**Our ref:** NO/2021/113948/01-L01  
**Your ref:** 3/2021/1020  
**Date:** 19 October 2021

**CONSTRUCTION OF 15 ECO LODGES AND INFRASTRUCTURE TO PROVIDE  
ADDITIONAL ACCOMMODATION FOR EAVES HALL.  
EAVES HALL, MOOR LANE, WEST BRADFORD, BB7 3JG.**

**Environment Agency position**

1 Proposed Site Plan
Scale: 1:500

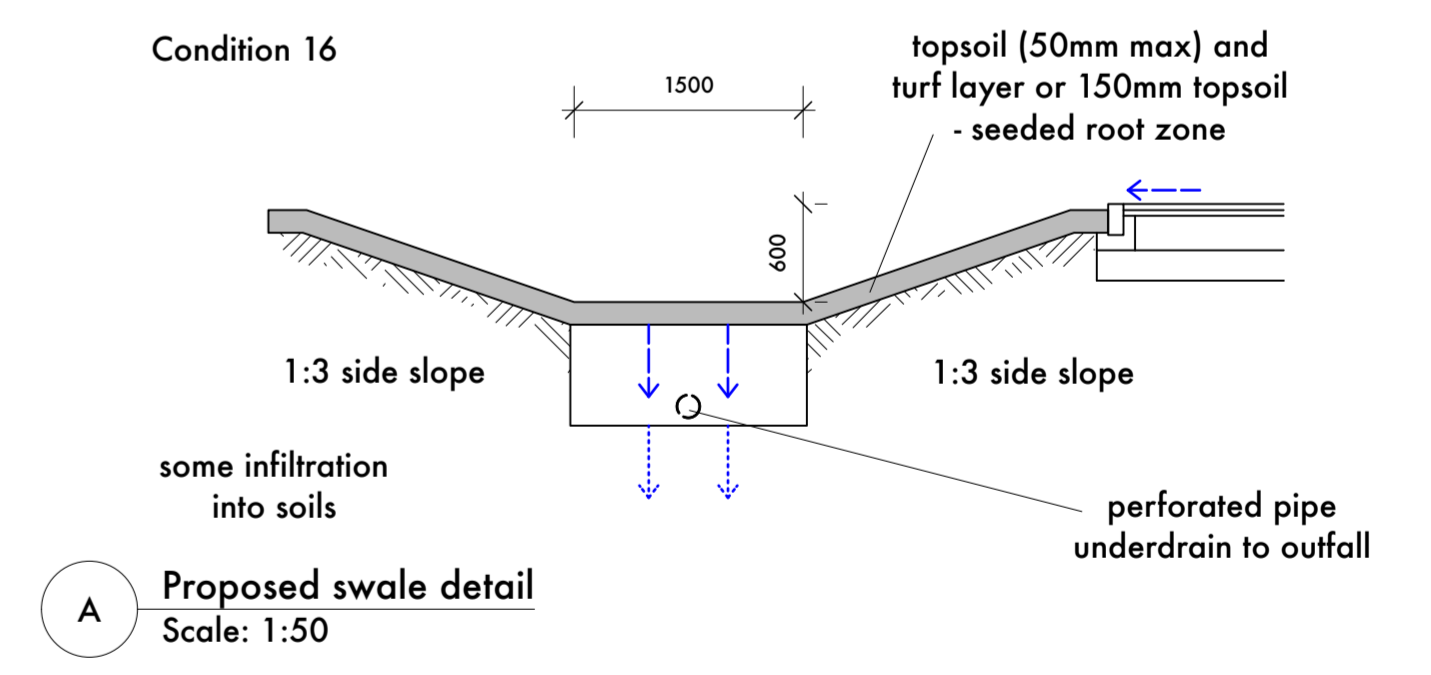
We have no objection to the variation of condition 2 as requested. We do however note that the plans still indicate the use of a septic tank for the purpose of foul drainage. We therefore take this opportunity to remind the applicant of our response dated 28 September 2020.

The plans with the current application indicate that there may be an economic justification for not connecting to the main sewerage system that could result in the use of a septic tank. We therefore remind the applicant that as there is a combined sewer within 30 metres of the site boundary, this would not satisfy the General Binding Rules governing foul drainage. Therefore, any discharge from a non-mains drainage system will require a permit from the Environment Agency. It should also be noted that if a mains connection is not possible, then the next step in the drainage hierarchy is the use of a package treatment plant rather than a septic tank.
